Ribble Valley Borough Council  
Housing & Development Control

Application no: **3/2023/0930**

Address: **Clayton Manor Ribchester Road Wilpshire Lancashire BB1 9HU**

Proposal: **Proposed construction of four one-bedroom apartments in a purpose-built detached garage with separate dedicated access off Knowsley Road, following demolition of existing garage.**

Drawing Title
PROPOSED CLAYTON MANOR LODGE SITE LAYOUT

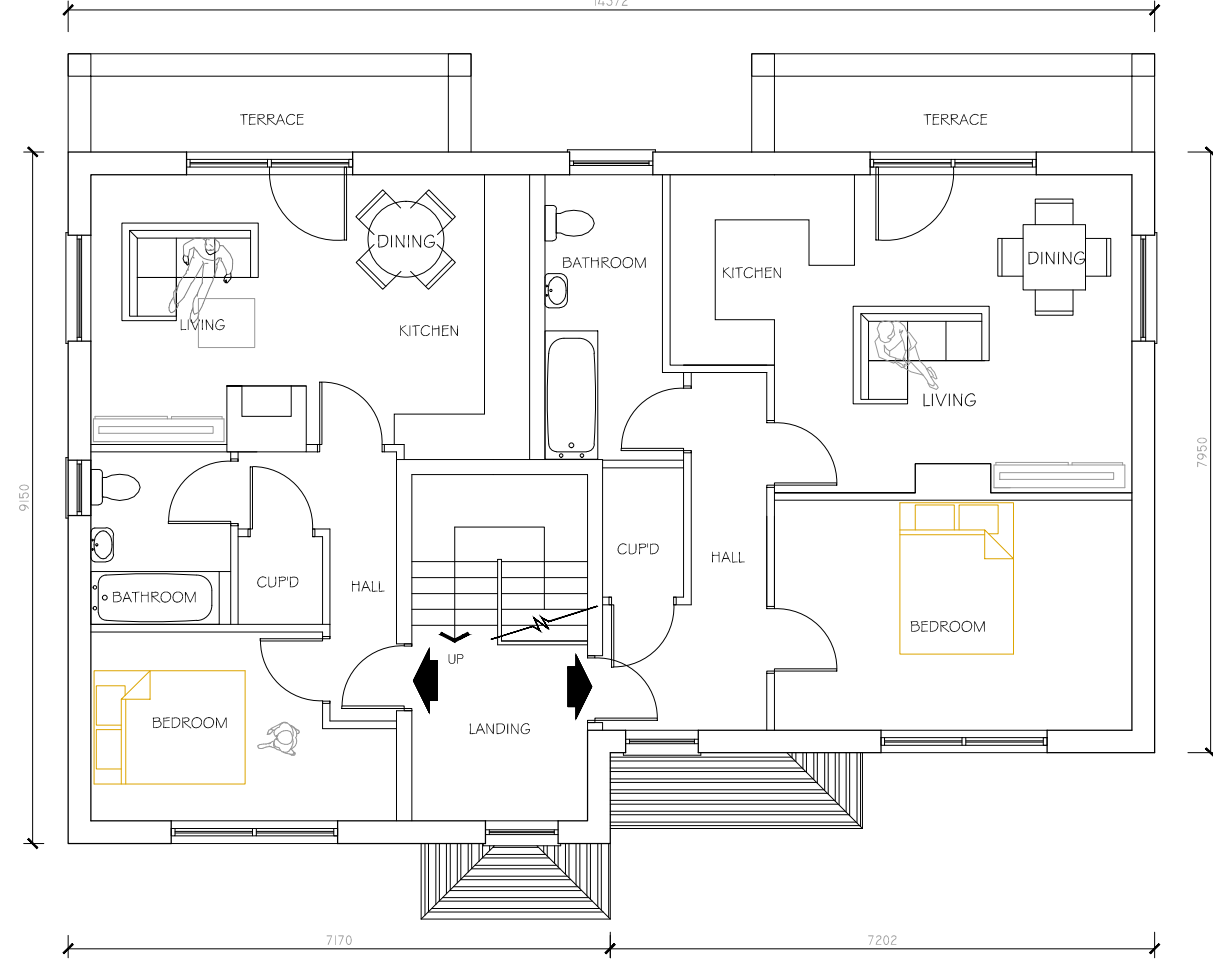
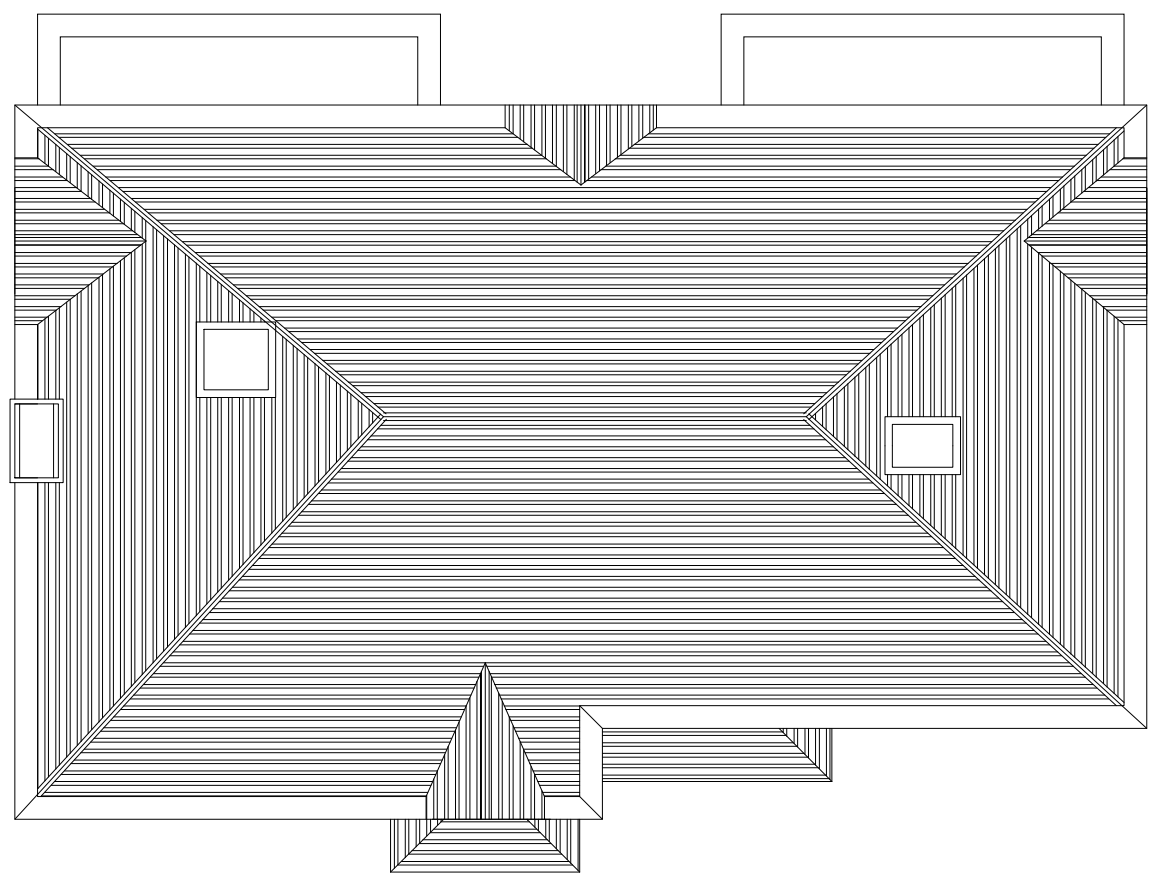
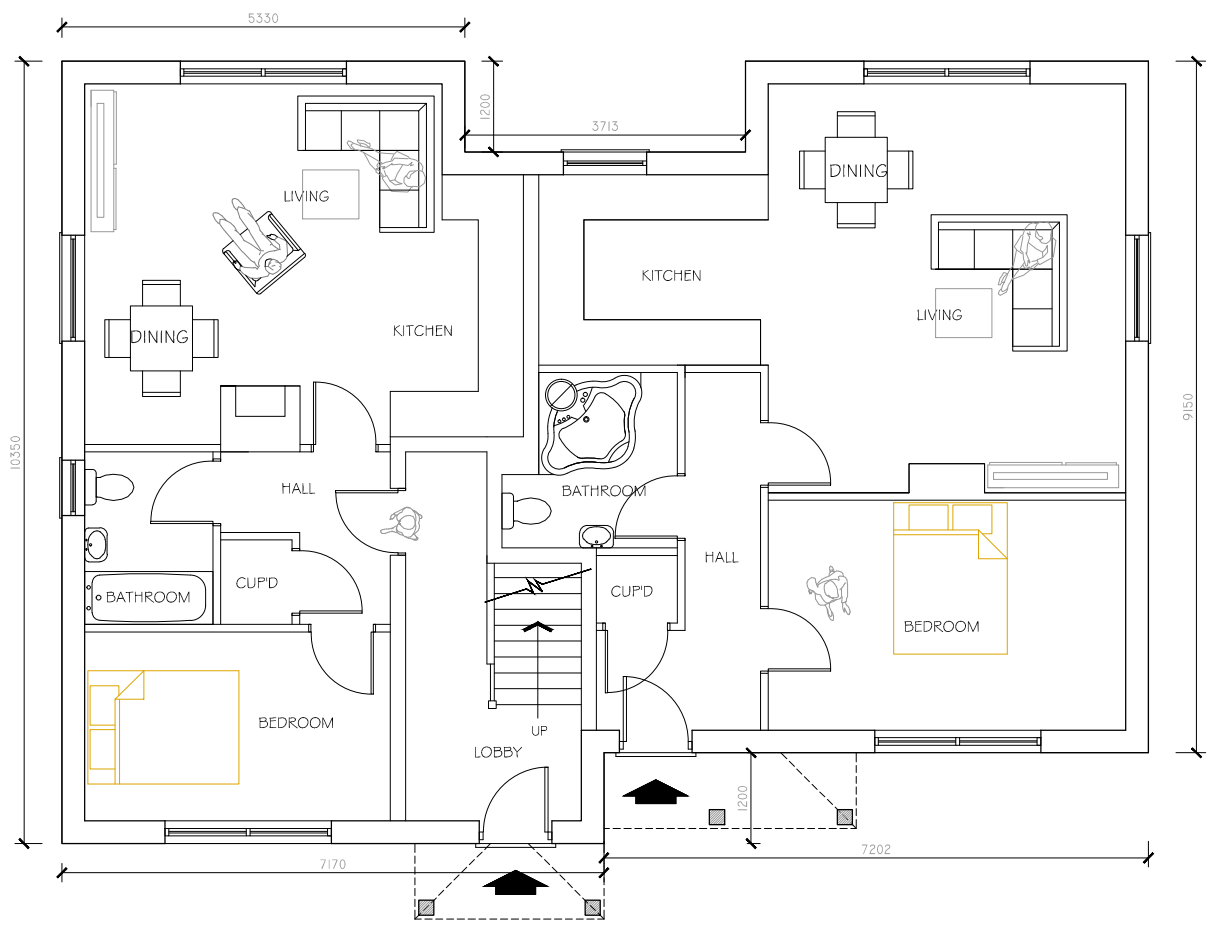
The site access which is shown on Phil Heaton drawing number 2101-02 Rev A titled "Proposed Clayton Manor Lodge Site Layout" will be located at the junction between Ribchester Road/ Knowsley Road. Ribchester Road is a B classified road subject to a 30mph speed limit, while Knowsley Road is a C classified road subject to a 20mph speed limit.

The LHA are unable to accept the location of the site access. This is because it is located at the junction between Ribchester Road/ Knowsley Road. Therefore, the LHA are concerned that the positioning of the site access will compromise the use and safety of the junction for road users.

For example, should vehicles from Ribchester Road want to enter the proposed site and there are vehicles queuing to safely exit the junction, vehicles will have to queue on Ribchester Road until the junction is clear, with even one vehicle waiting at the junction obstructing the use of the access. This is completely unacceptable and so the LHA are concerned that the location of the site access would compromise highway safety.

There are also concerns as to whether vehicles exiting the site access and turning left onto the junction, will be able to do so safely without overlapping the lane which allows vehicles from Ribchester Road to turn onto when accessing Knowsley Road. Should a swept path drawing show that vehicles exiting the site will overlap this lane, it would be to the detriment of highway safety with potential conflicts occurring should vehicles turn onto Knowsley Road and from the site access simultaneously.

Furthermore, the site access conflicts with the existing street signs and street furniture located at the junction. The LHA do note that these can be relocated in normal circumstances. However, there is a lack of space in this location belonging to Lancashire County Council and so it will be difficult to relocate these signs elsewhere.

The geometry of the site access also fails to comply with the LHAs guidance when serving 4 dwellings. The LHA require the access to be a minimum of 4.5m wide and any gates attached to the access should be setback a minimum distance of 5m from the adopted highway.

The LHA have reviewed Phil Heaton drawing number 2101-02 Rev A titled "Proposed Clayton Manor Lodge Site Layout" and are aware that 6 car parking spaces will be provided for the 4x one bed apartments. While the parking arrangements complies with the parking guidance as defined within the Joint Lancashire Structure Plan, only one of these spaces, P6, is likely to be usable or acceptable to the LHA as currently presented. This is because of the following which will be discussed below.

Firstly, parking space P1 is located too close to the access gate. Therefore, the LHA are unsure as to how a vehicle will be able to manoeuvre in and out of the space when a vehicle is parked in P2 and even when P2 is free. Similarly, the LHA are concerned that P4 will be unusable due to a complex vehicular manoeuvre being required to access and egress from the provided space. While P5 lacks the adequate reversing space, with the LHA requiring a minimum of 6m of free space behind to ensure that there is adequate space for a vehicle to turn and exit the site in a forward gear.

Should a swept path drawing be submitted which shows that a vehicle can manoeuvre in and out of the spaces without any conflicts, the LHA still have concerns with the internal layout of the site. This is because the site does not provide any internal turning facilities to ensure that all vehicles can exit the site in a forward gear. Unfortunately, the lack of turning facilities compromises the use of parking spaces P1 to P4 and also questions how delivery vehicles will safely service the site.

The LHA would expect and require internal turning facilities to be provided due to the LHA being unable to accept vehicles reversing onto a classified road as well as and maybe more detrimental to highway safety, vehicles reversing onto a junction, Ribchester Road/ Knowsley Road given the position of the proposed site access. Therefore, as presented, the lack of internal turning facilities will be to the detriment of highway safety with the proposal compromising the use and safety of the adjacent junction. This is contrary to paragraph 115 of the National Planning Policy Framework (2023).

To help overcome this objection, the LHA advise that the access serving Clayton Manor may be more suitable to serve the proposed site following access improvements. The LHA advise the Agent/ Applicant to submit a pre-application to the LHA to discuss these requirements outside of the planning process.
